CITY OF ALBUQUERQUE

December 15, 2022

**Re: El Encuentro Immigrant Community Center
907 4th St. SW
30-Day Temporary Certificate of Occupancy
Transportation Development Final Inspection**
Architect's Stamp dated 01-21-22 (K14-D121)
Certification dated 10-31-22

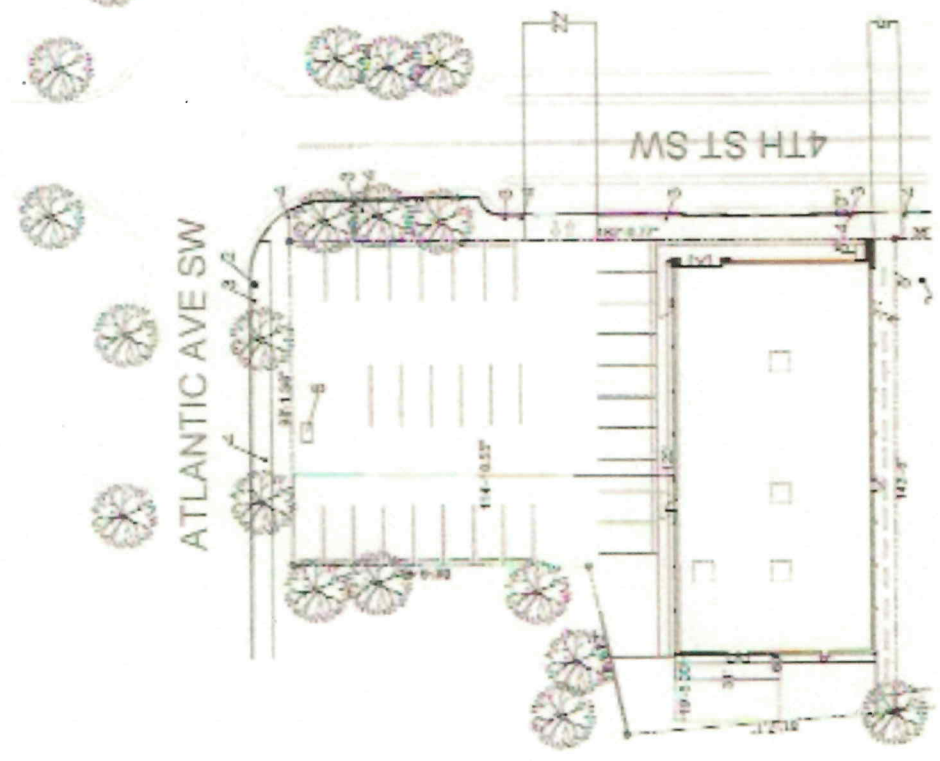
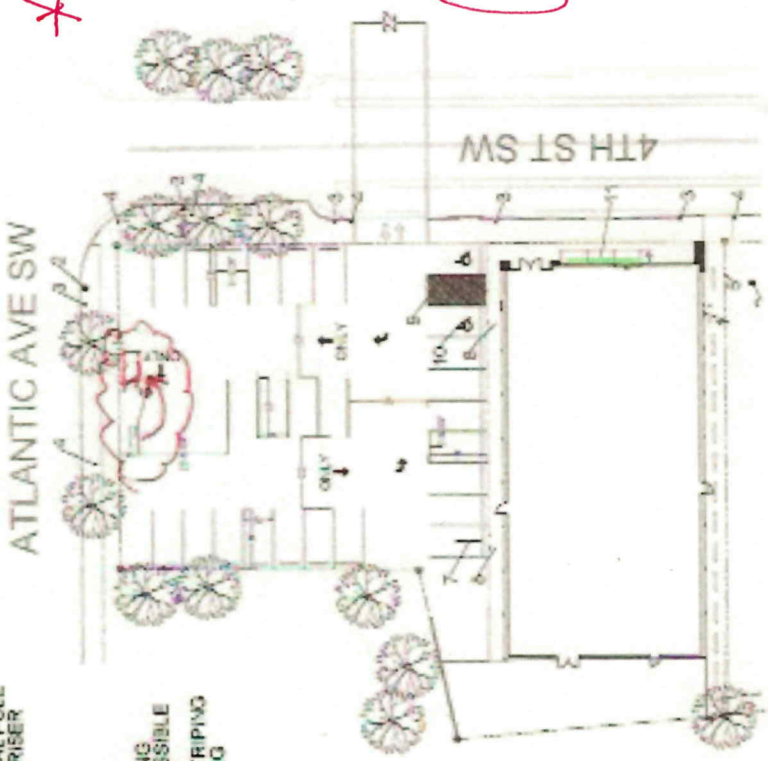
- Please provide City Right of Way improvements project number.
Once these corrections are complete, email pictures to malnajira@cabq.gov for release of Final CO.
